PLANNING CONSULTATION RESPONSE

Application No	2025/0912
Proposal	Erection of single storey side and rear extension and creation of parking facilities to the front of the property.
Address	55 Armroyd Lane, Elsecar, Barnsley, S74 8ET
Date of Consultation Reply	25.11.2025
Consultee	Charlie Atkinson Design & Conservation Apprentice

This application seeks planning permission for the erection of a single-storey side and rear extension, together with the creation of parking facilities to the front of 55 Armroyd Lane, Elsecar.

PROJECT	Extensions & Alterations	
CLIENT	Mr. & Mrs. L. Hollingworth	
TITLE	Elevations as Proposed	
ADDRESS	55 Armroyd Lane, Elsecar, Barnsley. S74 8ET	
DRAWN BY	ggg	
SCALE	1:100 @ A3	DATE Mar 25
DRAWING No	515-05	REV A

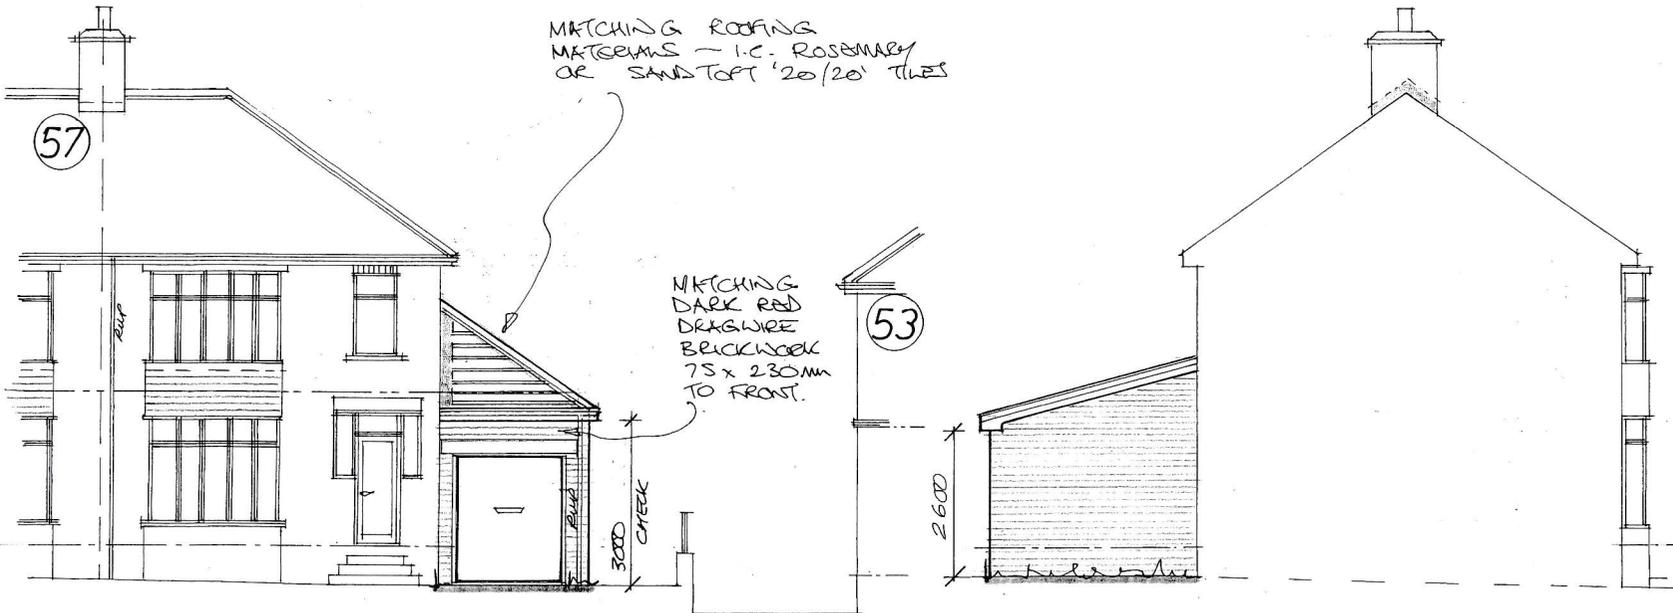
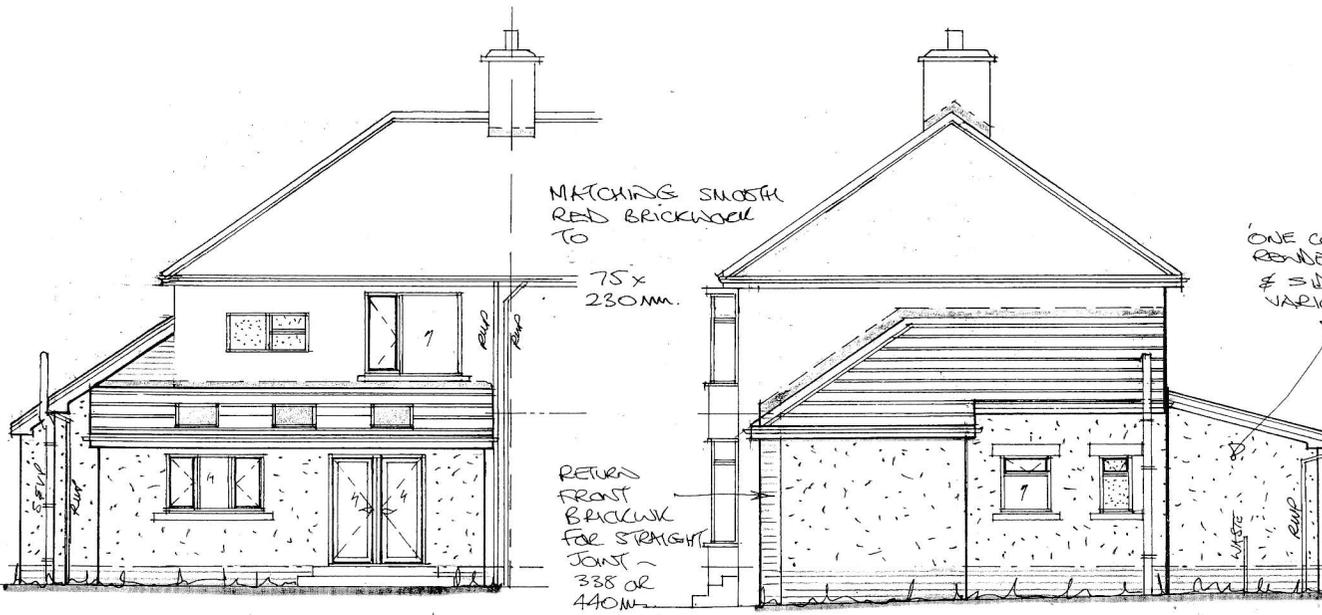
Due to cost considerations, the current proposal has been reduced to a single-storey side and rear extension. Previous comments regarding materials have been noted: the original scheme proposed Dark Red Dragwire brickwork. The revised proposal has respected this condition and has retained the dark red Dragwire brickwork on the front elevation but has introduced a one-coat render finish to the side and rear extensions, with matching roofing.

Although this change may seem minor, the introduction of render is considered out of keeping with the character of the conservation area and the architectural interest of this inter-war property. If the render was omitted and replaced with the matching brickwork consistent with the main elevation and wider building, the development would be acceptable from a conservation perspective.

As works had already commenced on site, and the breeze block walling for the render was in situ, a compromise was proposed by the planning officer to implement a brick-effect render in line with the comments above. While the rationale for a brick-effect finish could be seen as a compromise, the quality of such finishes is typically unconvincing and generally poor. Therefore, on balance, I consider a solid colour render, as proposed, to be acceptable given that the building itself holds little architectural merit.

Subject to this amendment, the proposal is recommended for approval.
